From: Jack Karagoz [REDACTED]
Sent: 08 September 2026 14:24
To: Simon Davis <Simon.Davis@arun.gov.uk>
Cc: Rebecca Hornsby [REDACTED]
Subject: RE: WA/18/26/PL - Land off Arundel Road Fontwell

The overall masterplan was based on the previous (withdrawn) outline application for which was agreed with the LLFA. This was based on infiltration and followed a full winters ground water monitoring. Based on the agreed parameters, standard 2 would have been met in full. However, this guidance wasn't in place at that time.

As part of this application, the drainage approach is now to provide a system of linked porous pavements which link to a shallow detention basin with a controlled outfall into a highway drain. Roof water will drain into the porous pavement.

Drainage Plans and Calculations

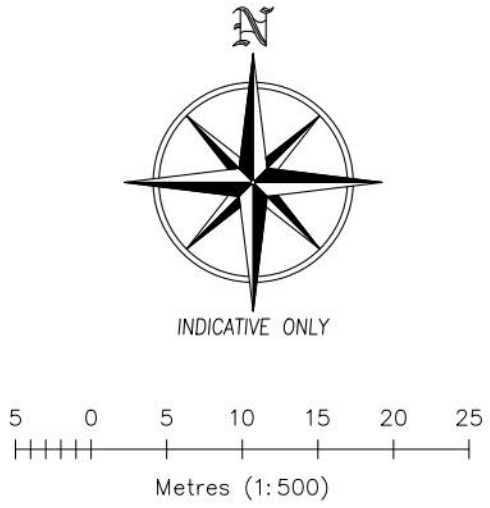
We originally reviewed standard 2 using the simplified approach as set out in the guidance. This states that where the permeable surface also drains an adjacent impermeable area and is lined, compliance shall not be deemed to have been achieved.

We have now reviewed this standard further and have provided further evidence in the form of calculations to compare the volume of porous paving with the volume generated from the first 5mm of rainfall. This is shown below and shows the volume within the porous paving to far exceed the volume of rainfall.

Ref	Length	Width	Area	Depth	volume	Contributing Area	Volume of first 5mm
PP 1	105	8.8	923	0.80	194	1447	7.2
PP 2	73	7.5	548	0.80	115	1343	6.7
PP 2A	23	14.5	334	0.50	40	334	1.7
PP 2B	23	6.2	143	0.80	30	279	1.4
PP 3	48	12.9	621	0.80	130	1132	5.7
PP 4A	44	5.2	228	0.80	48	438	2.2
PP 4	83	6.1	504	0.80	106	1671	8.4
PP 5	50	9.1	454	0.80	95	659	3.3
PP 6	120	8	959	0.80	201	2007	10.0

Given the porous paving has been designed to accommodate both its own surface area and the adjacent roof area which drains through it whilst also conveying the surface water, it can be seen to act like a swale than a standalone porous pavement.

The standards state that a lined swale can accommodate an impermeable area five times its plan area.

If the factor of 5 is applied to the total area of porous paving (4,714m²) this will accommodate a total impermeable area of 23,570m² double the actual impermeable area of 10,030m². It is also worth noting that flows will pass through the planted basin which will act as a swale for low flows which will accommodate a further 2,995m² of impermeable area (599m² x 5).

Based on the above - it can be seen that the first 5mm of runoff can be accommodated on site, therefore standard 2 can be met and trust the LLFA objection can be removed.
